# 312 Lisgar Street

Urban Design Brief  
June, 2025

# Response to Urban Design Comments

This section provides a response to comments received from Urban Design staff on January 14, 2025, following the pre-consultation meeting held on January 7, 2025.

1 NORTH ELEVATION
1 : 50

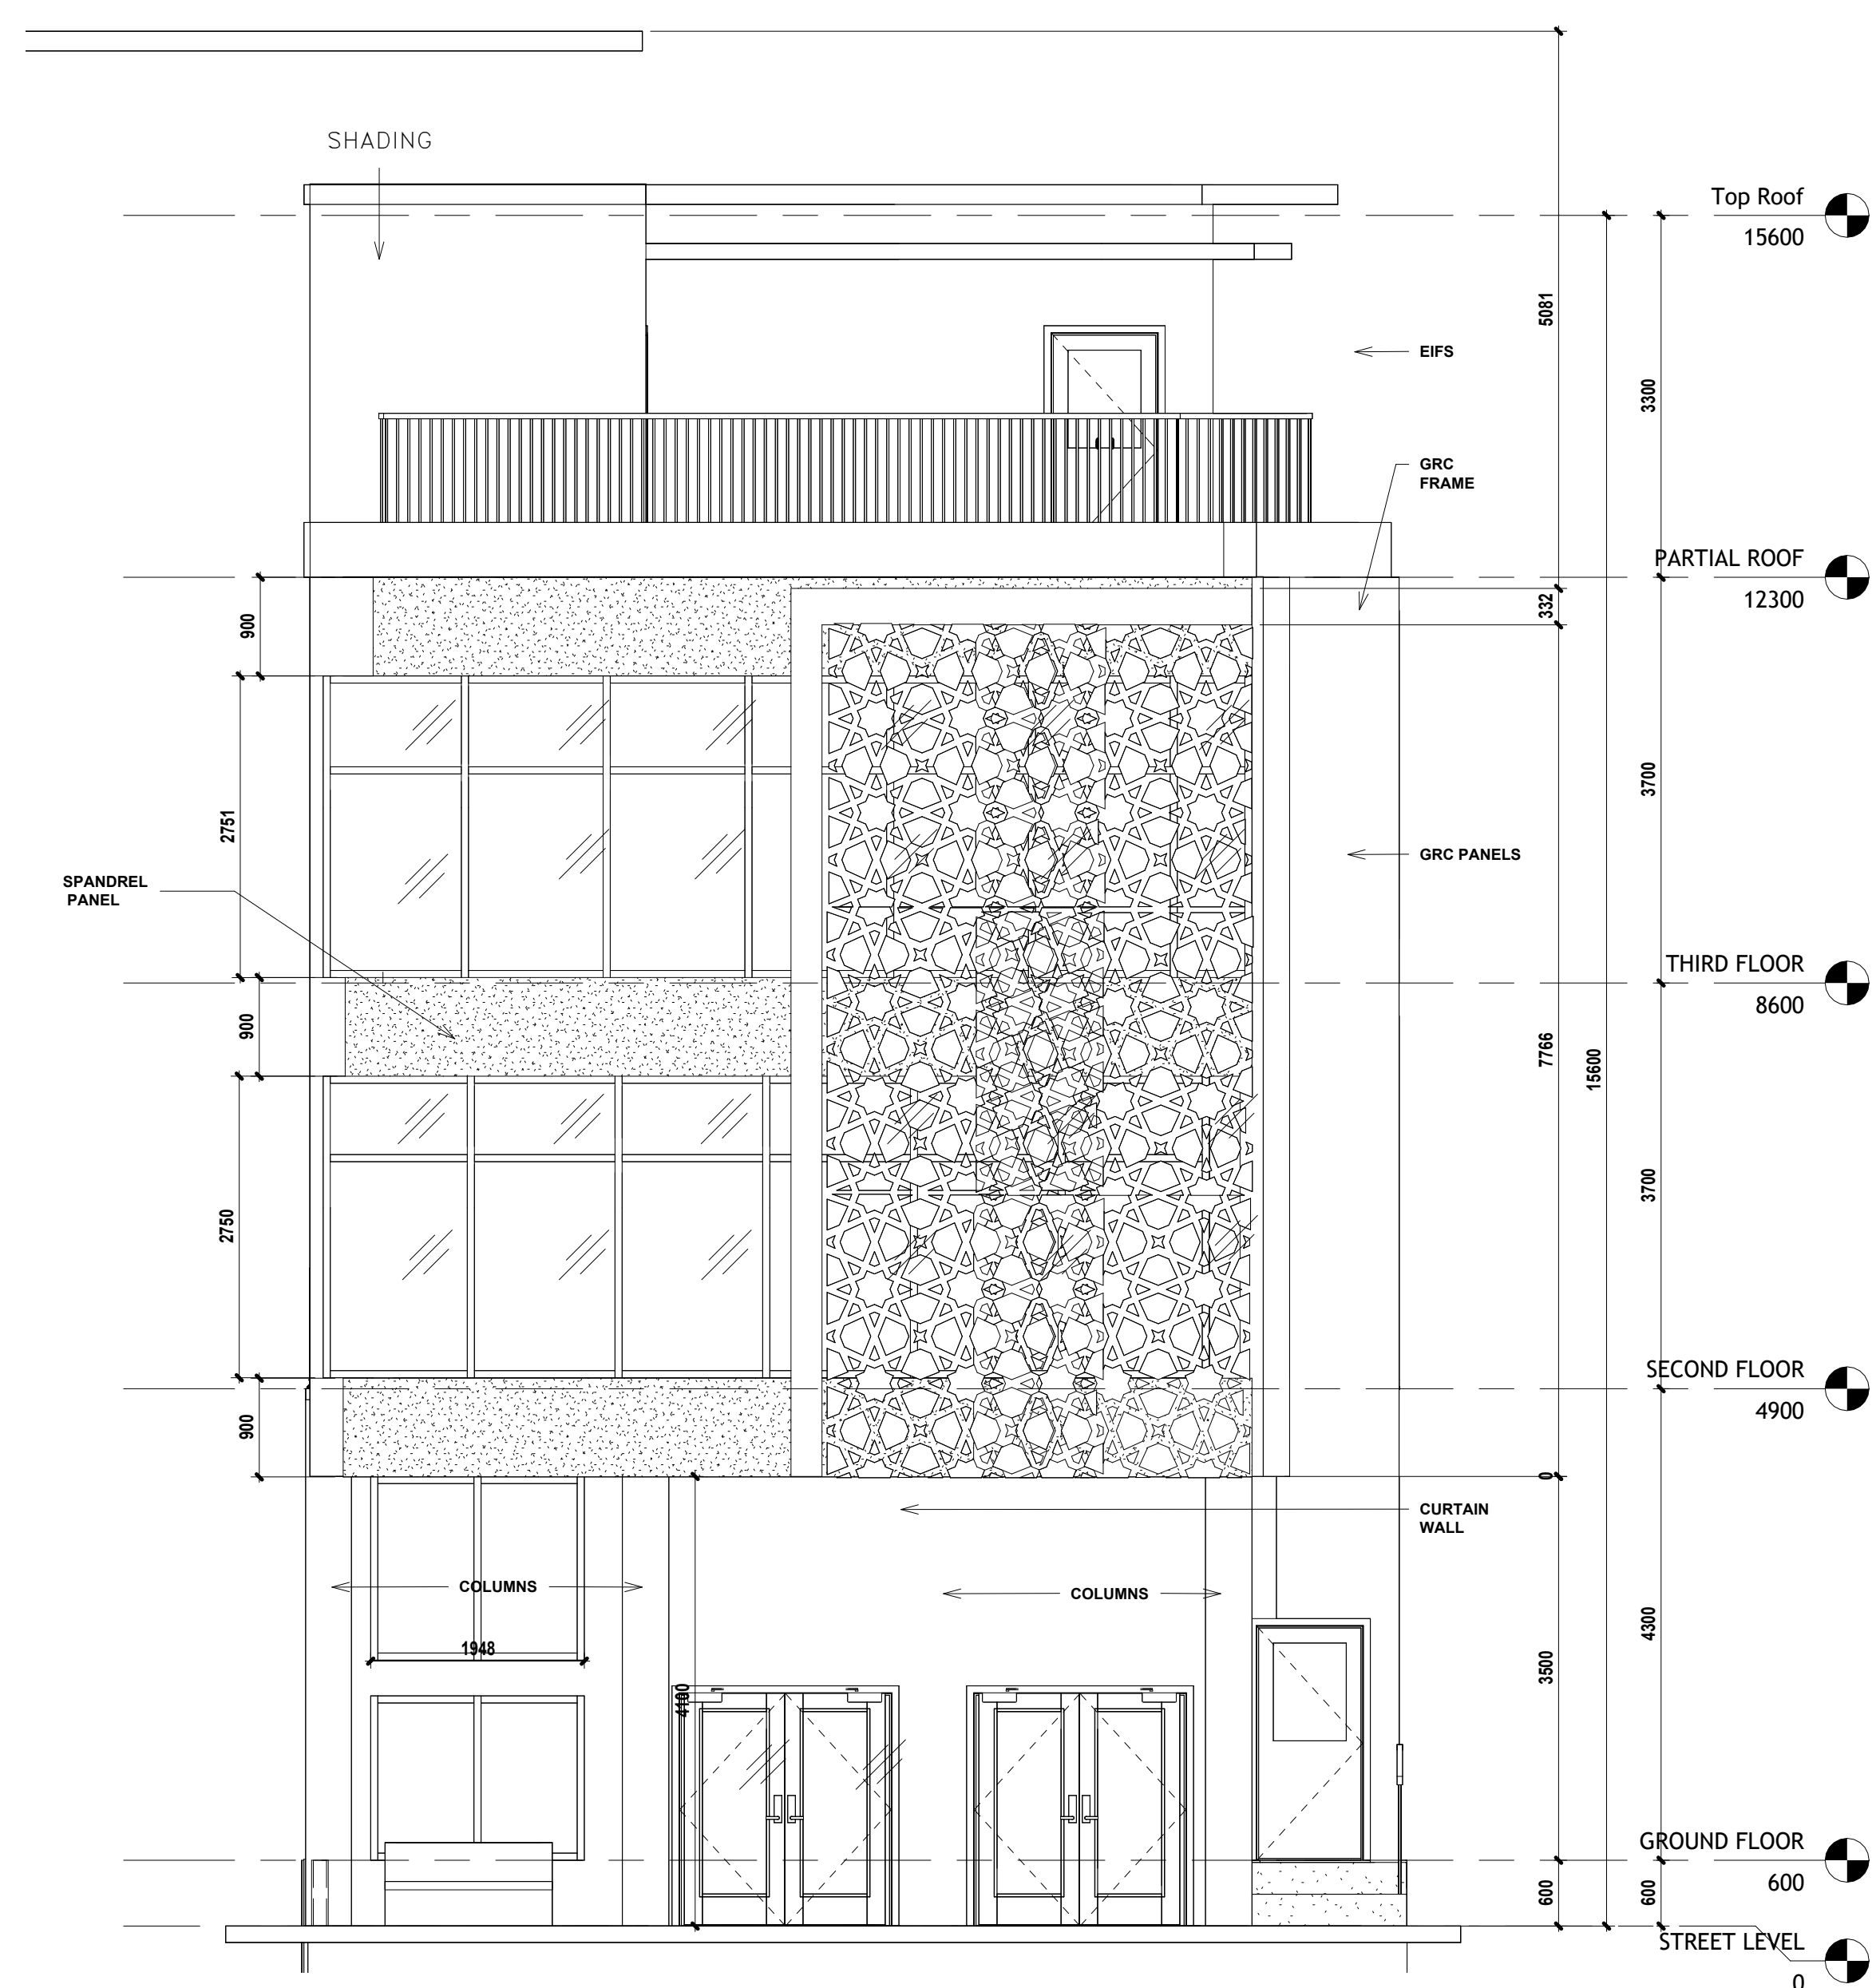
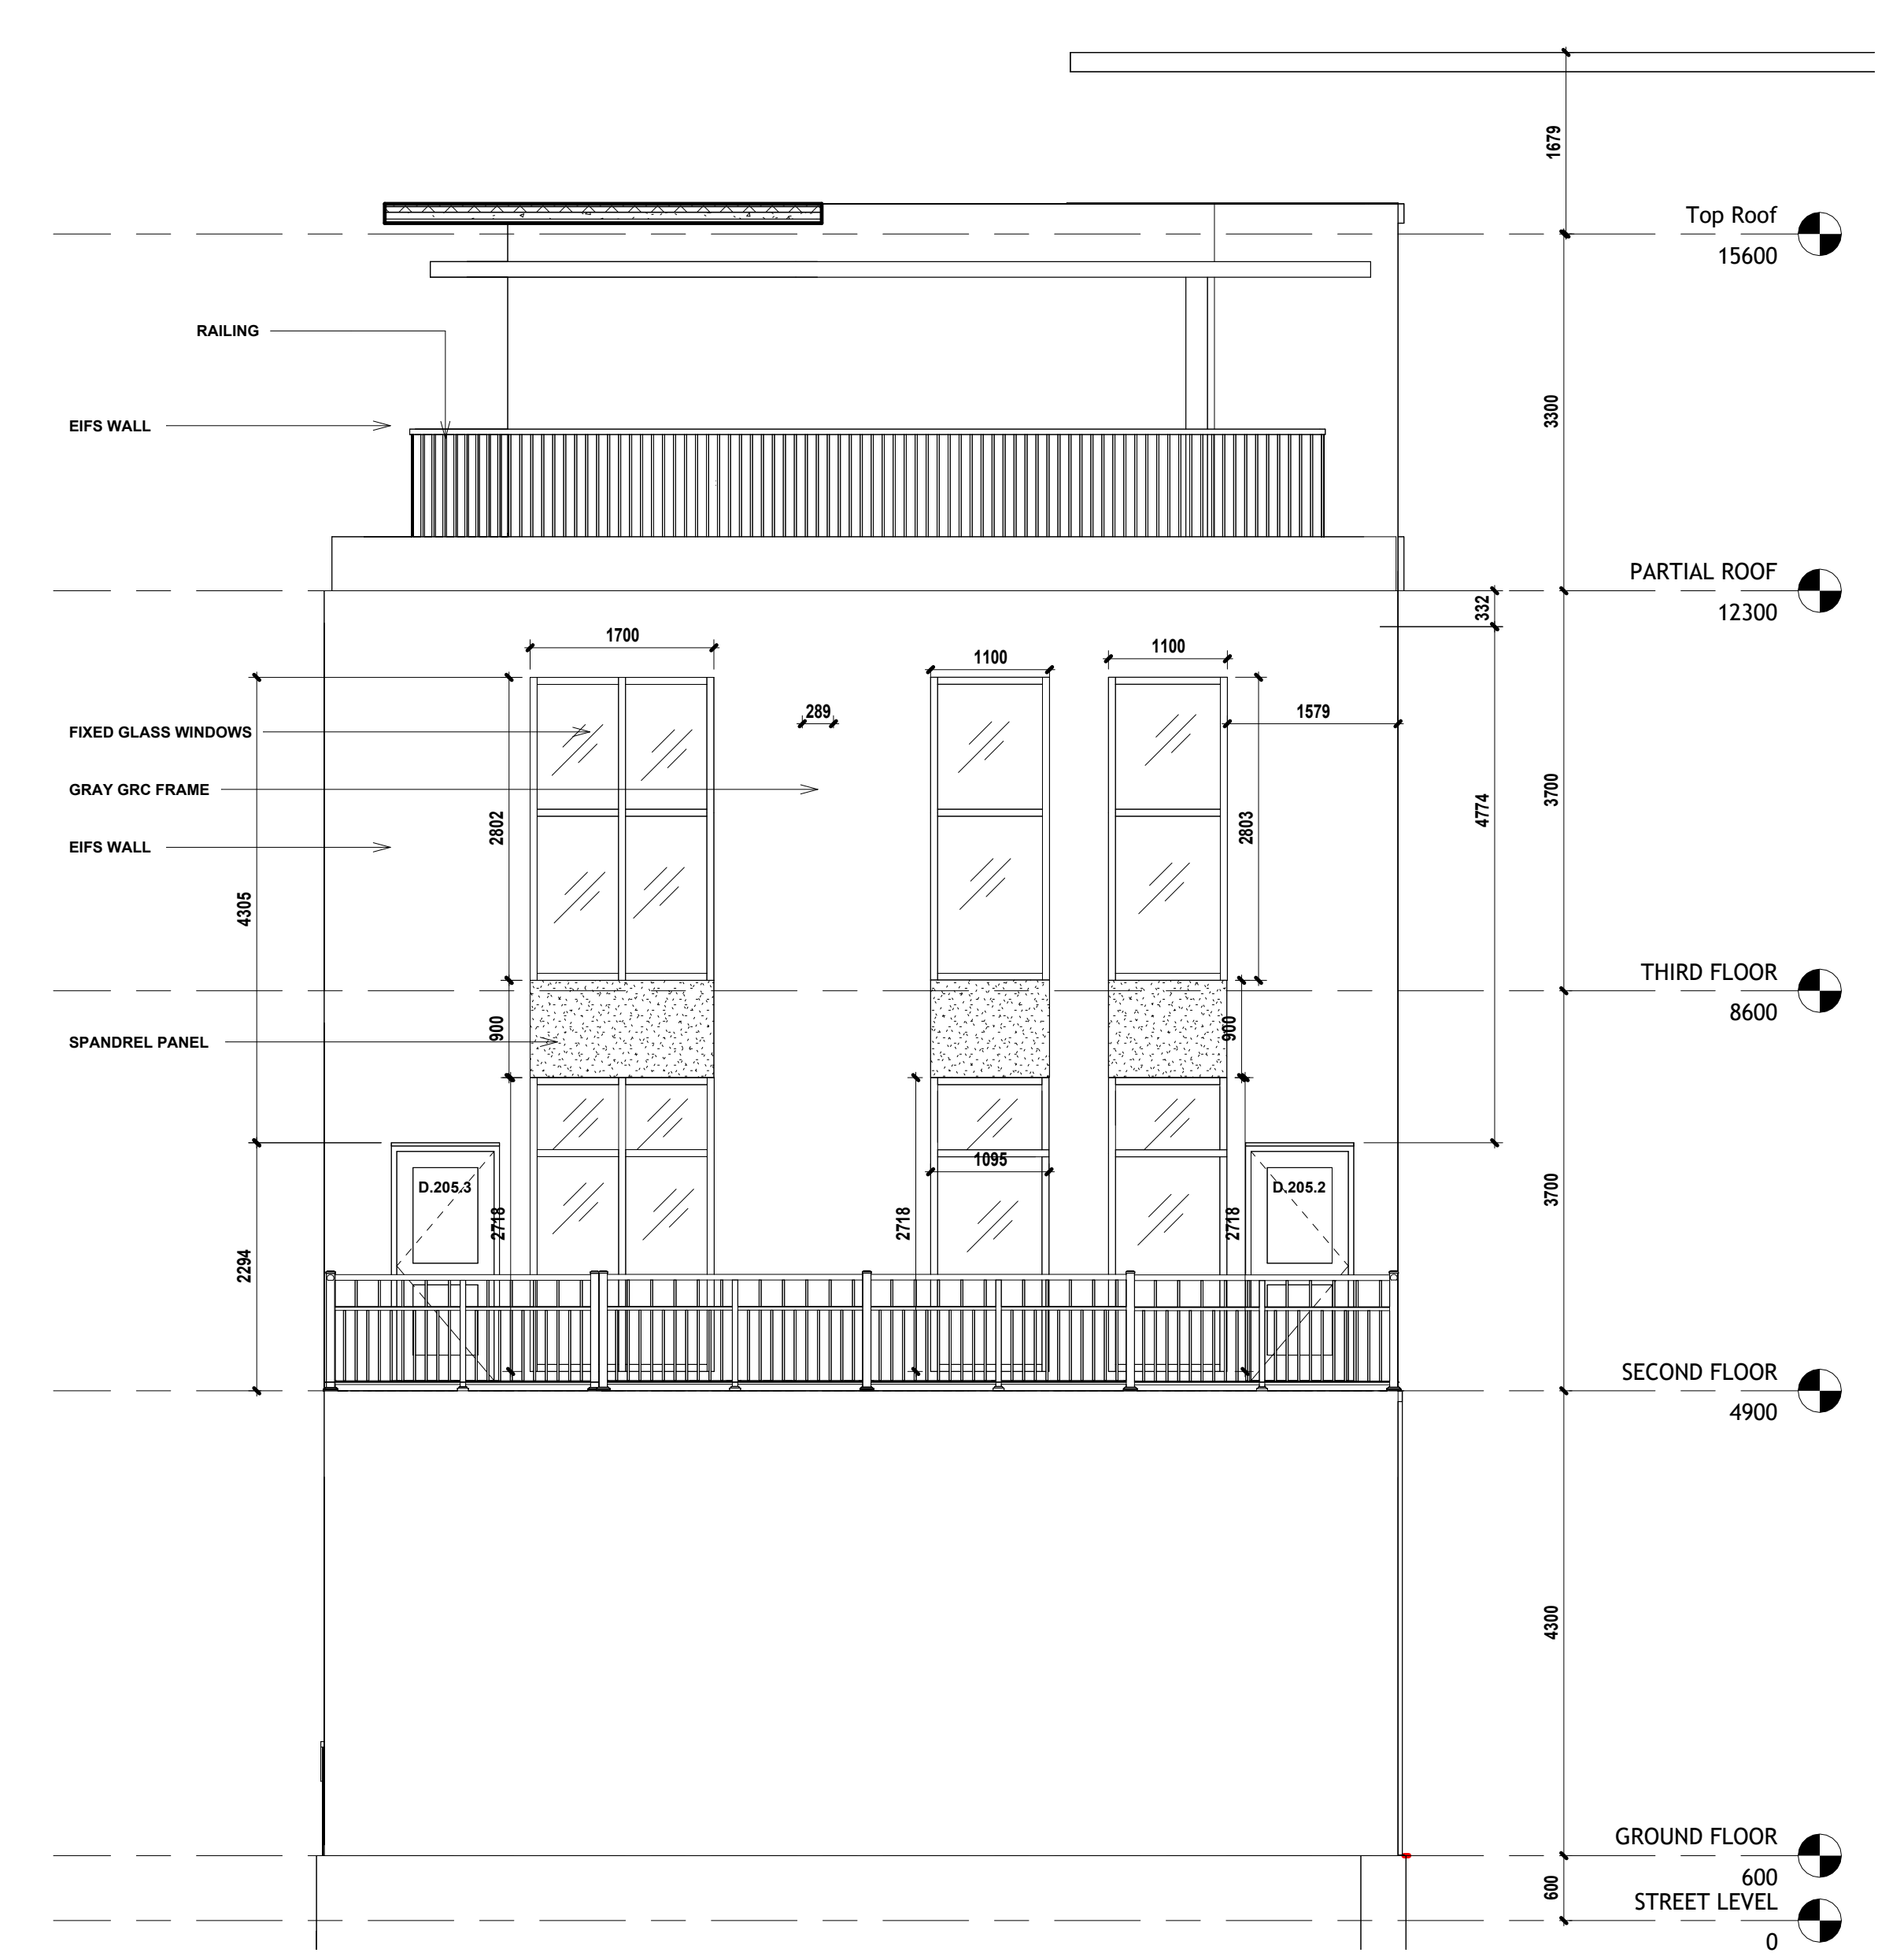
City Comment 13. With the minimal side yard setbacks proposed, please ensure that the blank wall conditions contain murals or some form of architectural treatment.

**Response: Decorative panels are proposed on the east and west facade to add visual interest along the blank walls. The ground floor is animated with transparent glazing and the upper floors are articulated with windows.**

Sheet Name
WEST ELEVATION

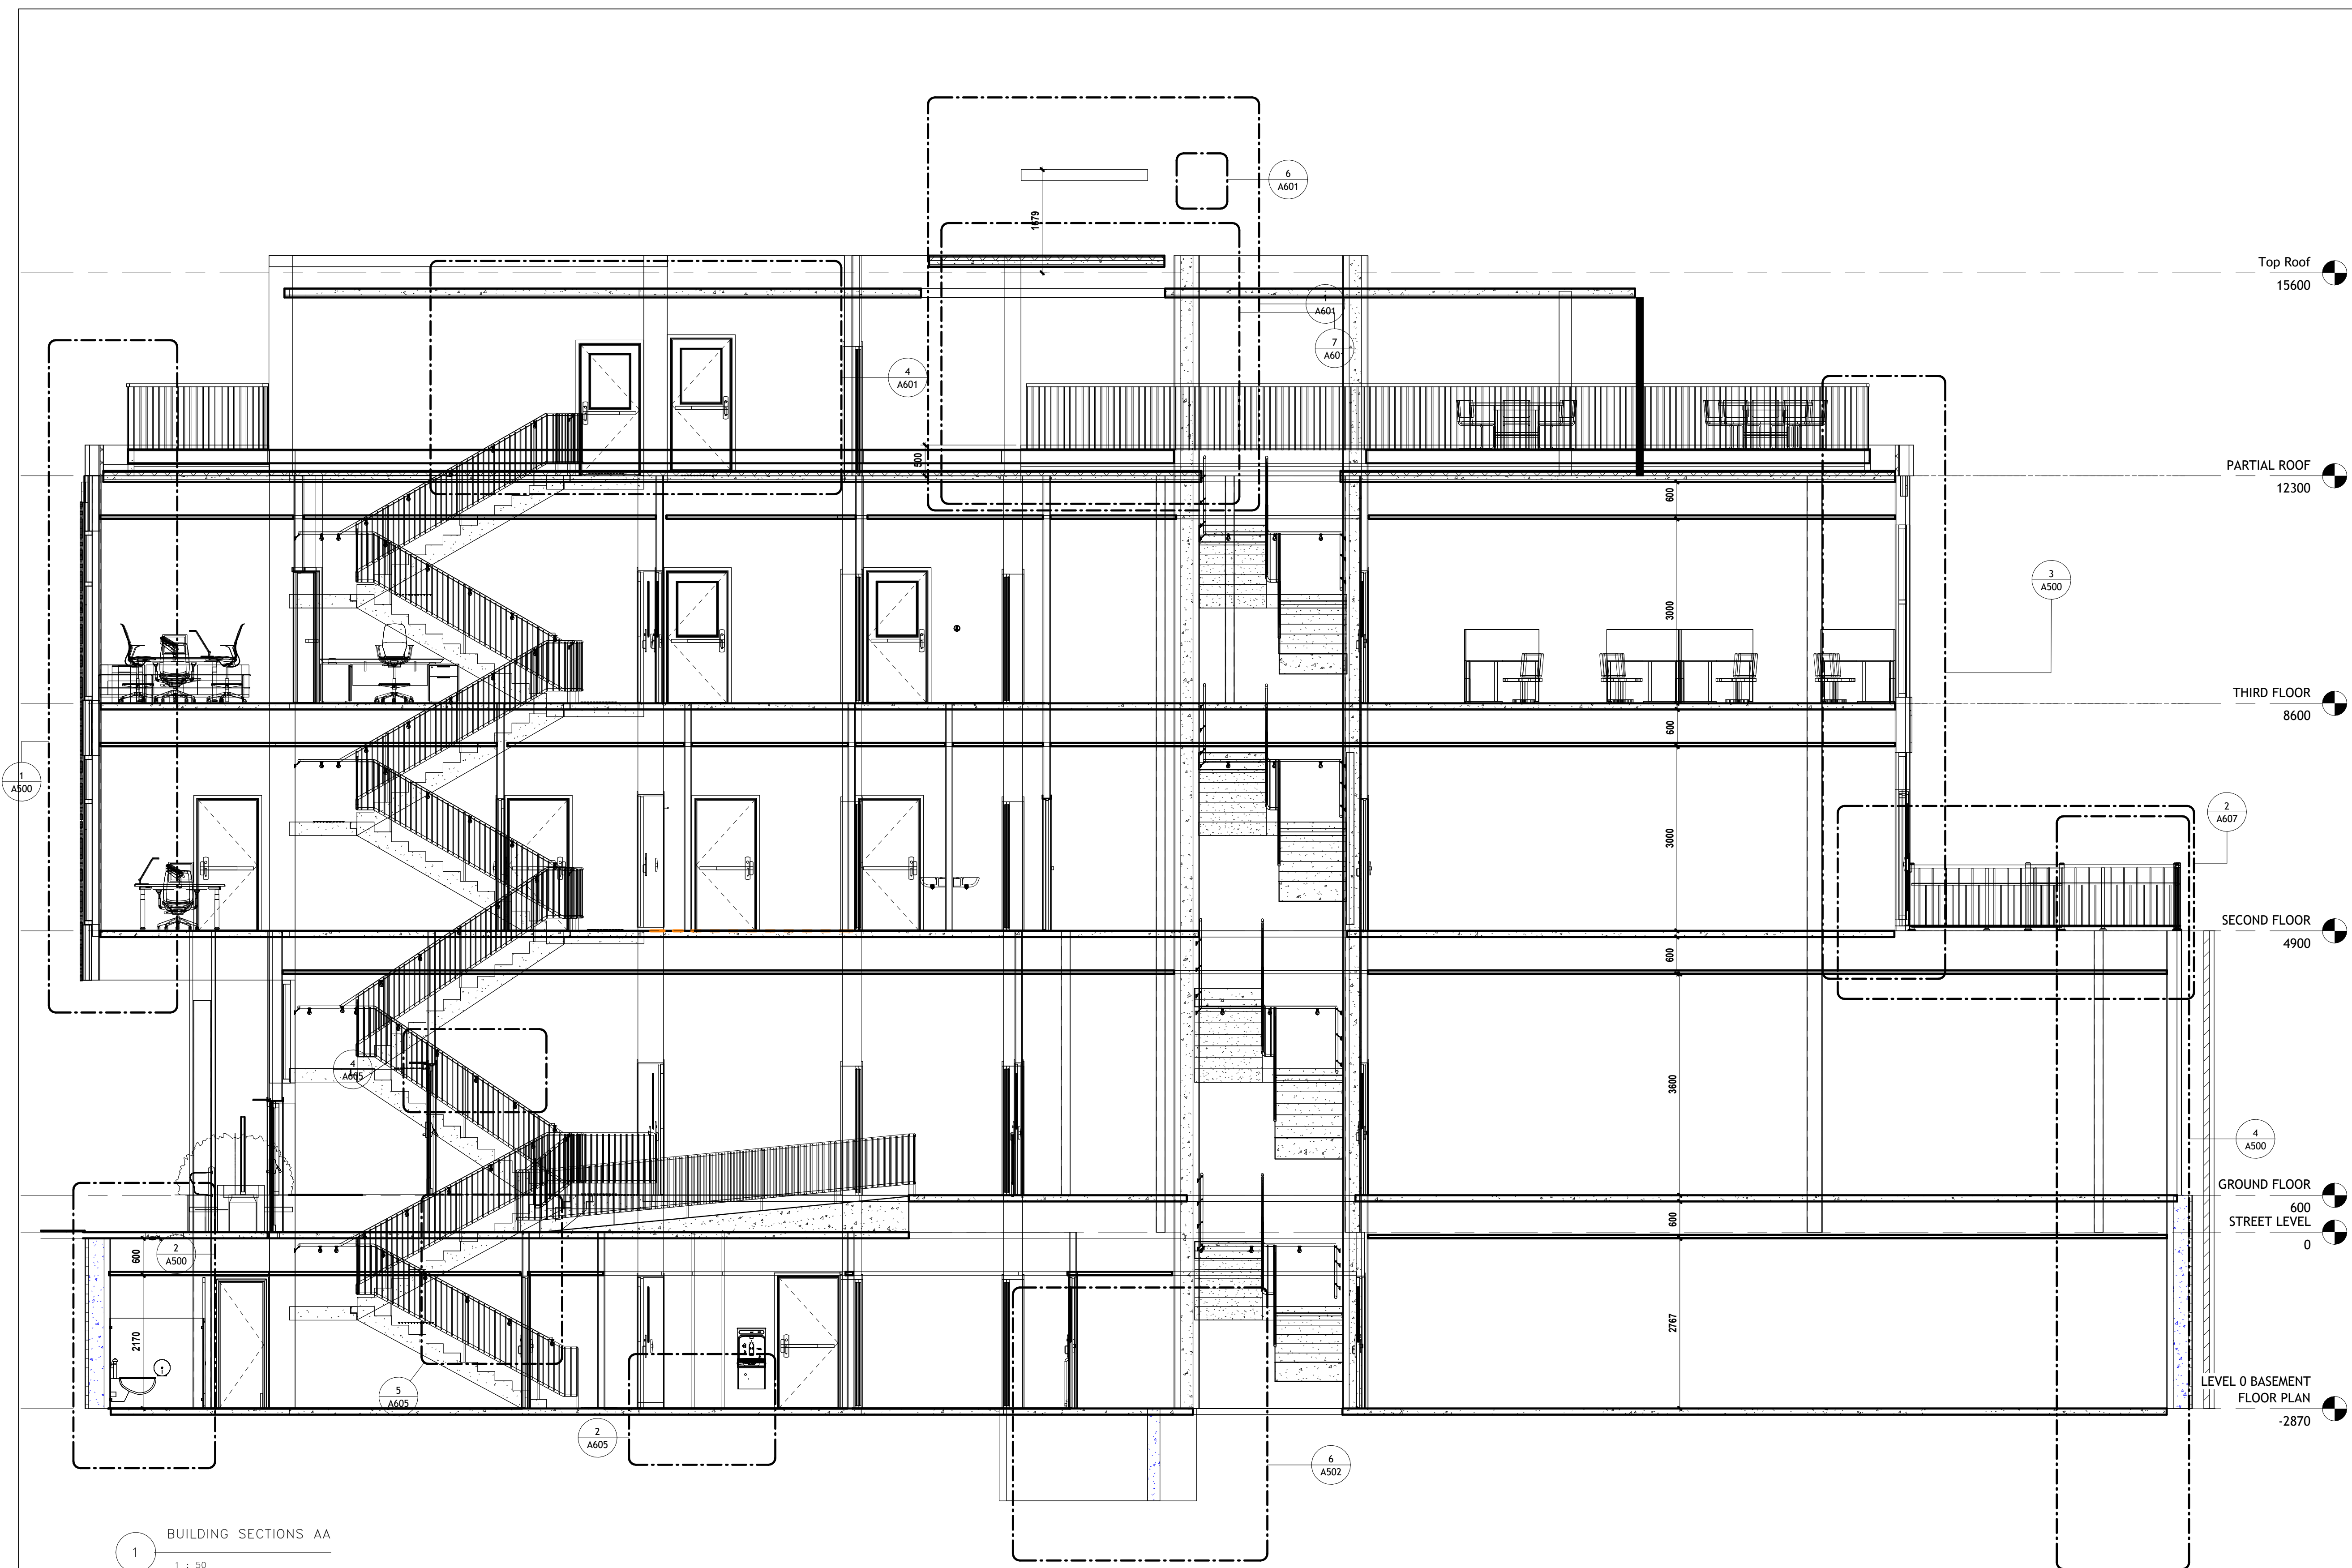
City Comment 12. Staff have concerns around light access with the planned context of the area. Please consider stepbacks at the upper levels and lightwells where appropriate to ensure that there is sufficient light access.

**Response: Glazing has been proposed along the ground floor of the building, and rooftop amenity space has been provided towards the rear (south) of the building. A stepback is proposed above the first storey from the rear lot line. Fotenn notes that the ground floor setbacks and windows along the west edge of the property will need to be revised to meet building code regulations.**
